February 6, 2024

Re: Whole Foods
2100 Carlisle Blvd NE, Suite A
Request for Certificate of Occupancy- 30 Day Temp
Transportation Development Final Inspection
Plan Date: Stamp 6-29-21, AA 12-4-23 (H17D097B)
Certification dated 1-28-24

SITE PLAN FOR BUILDING PERMIT

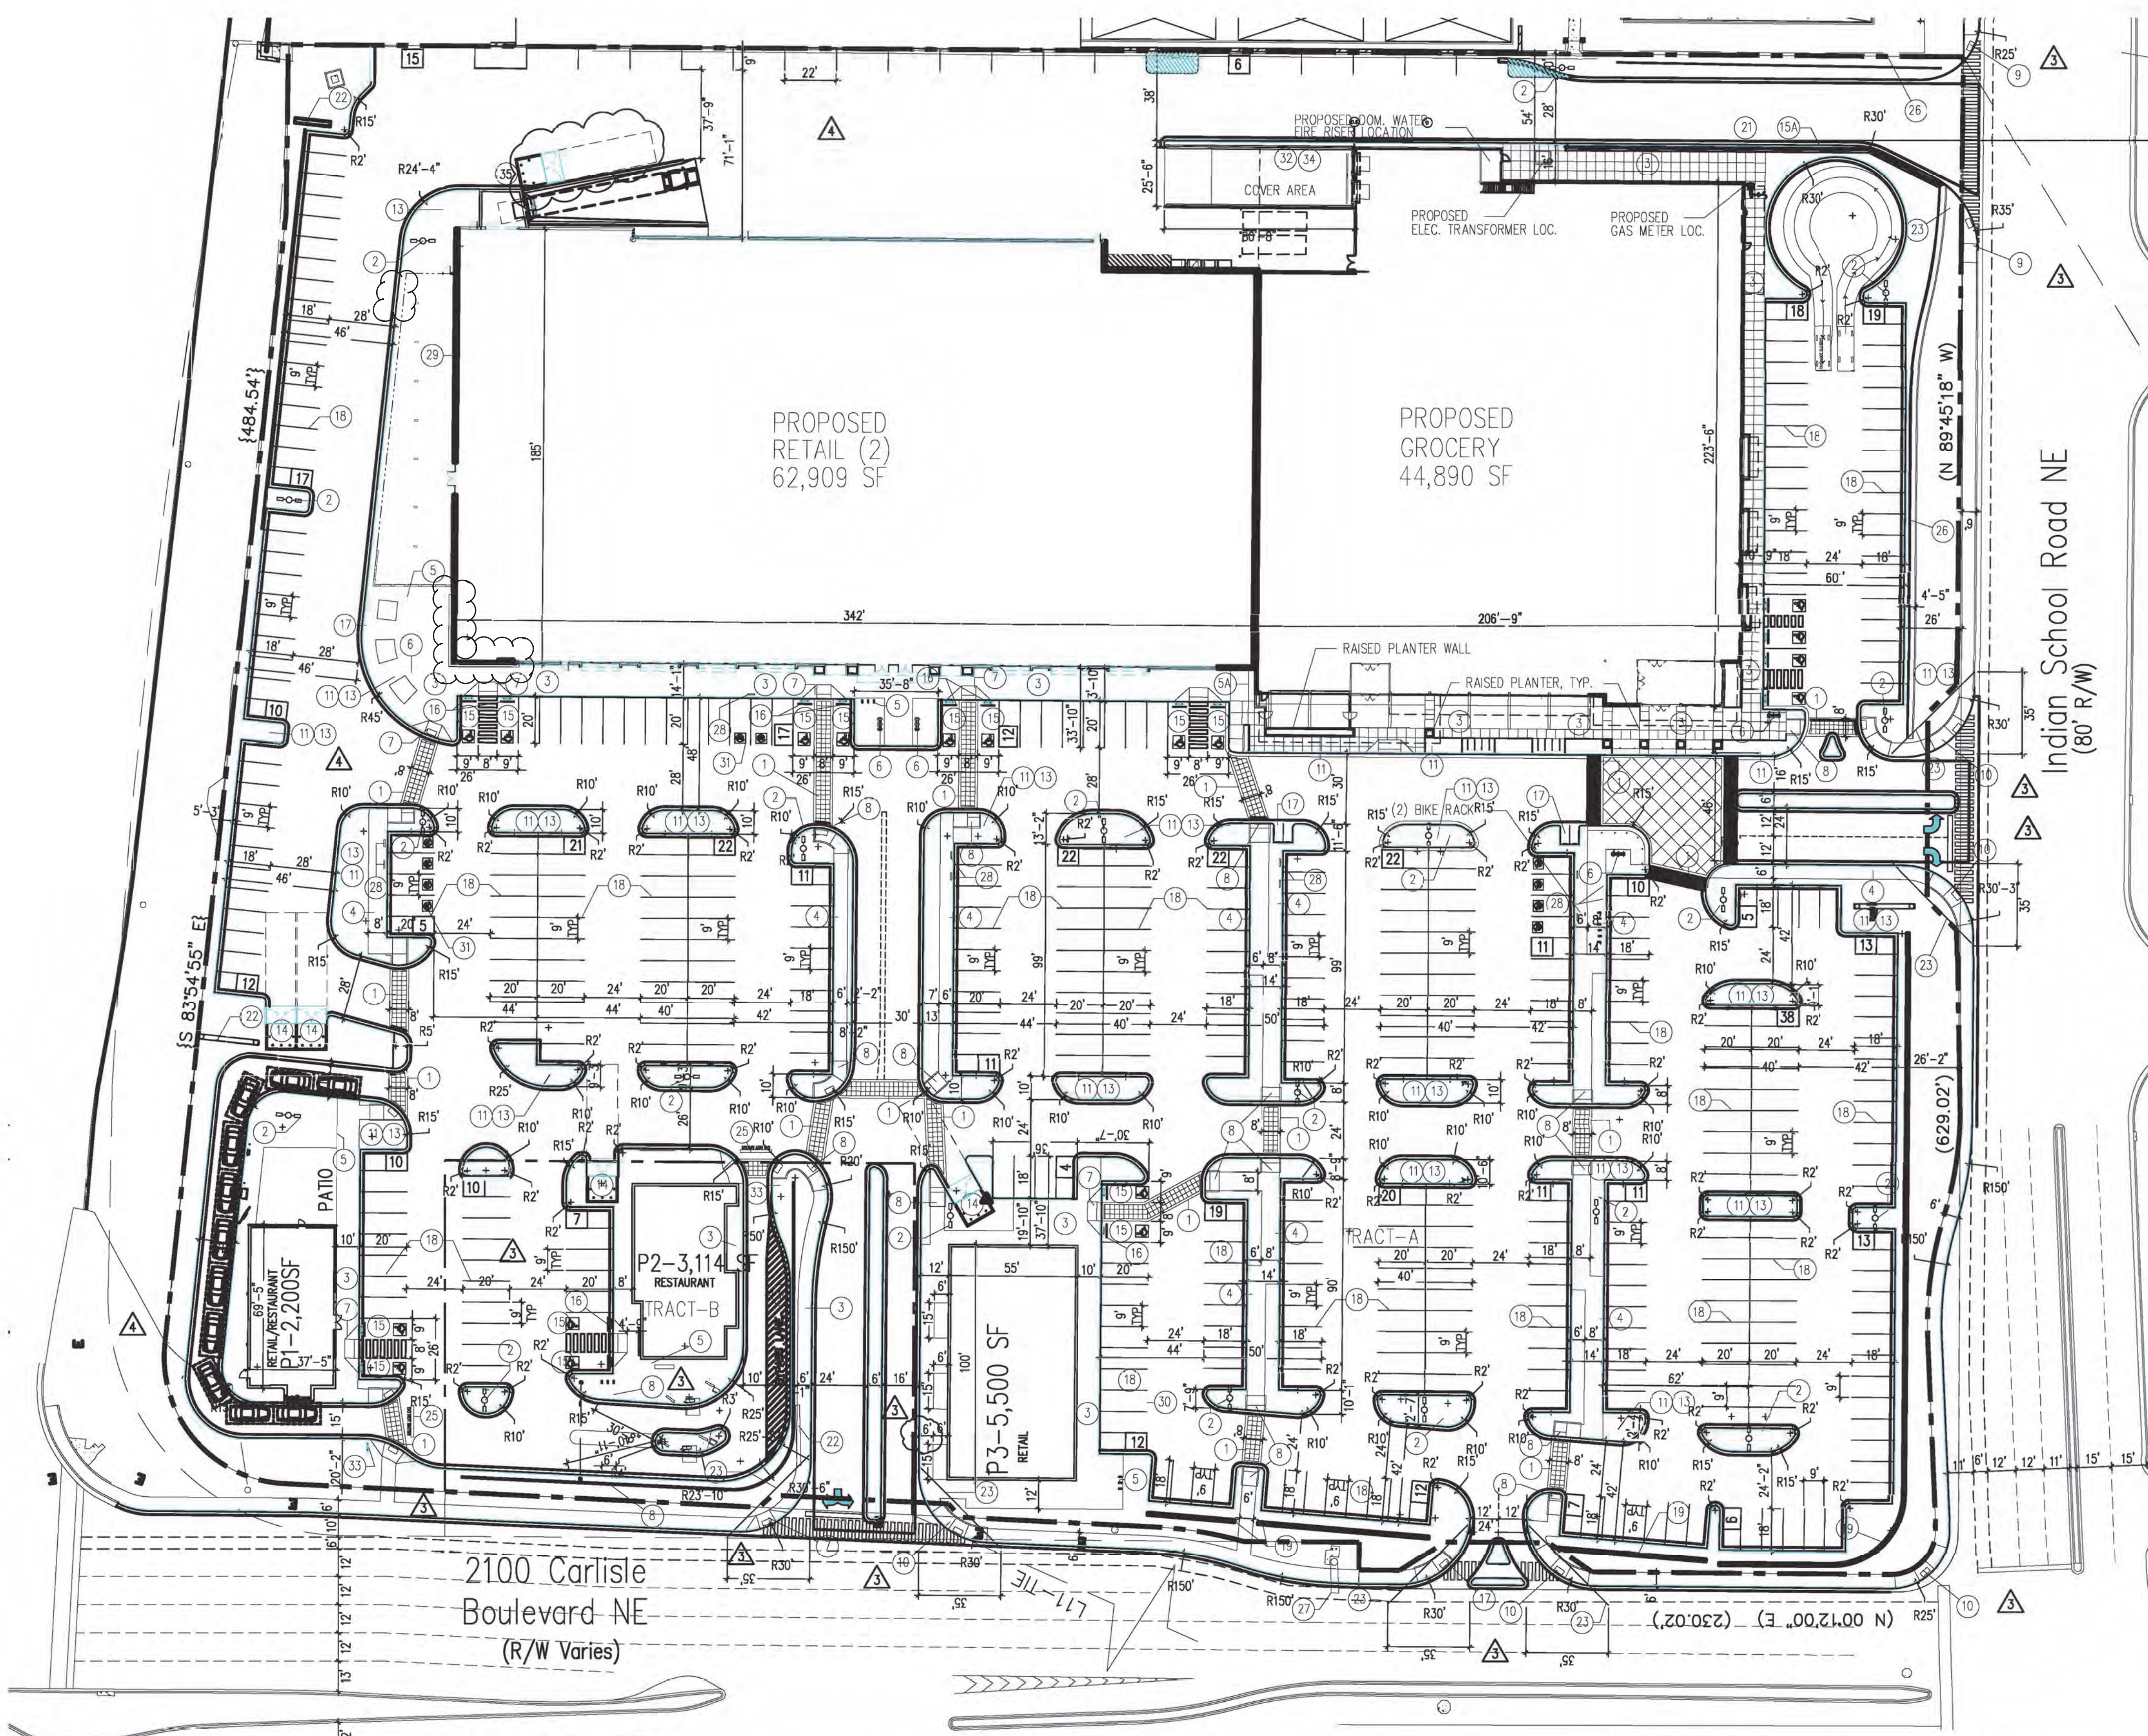
1. The Conex box is to be removed from the parking lot.
2. Add truncated domes to the ramps for the pedestrian pathway from Indian School Rd.
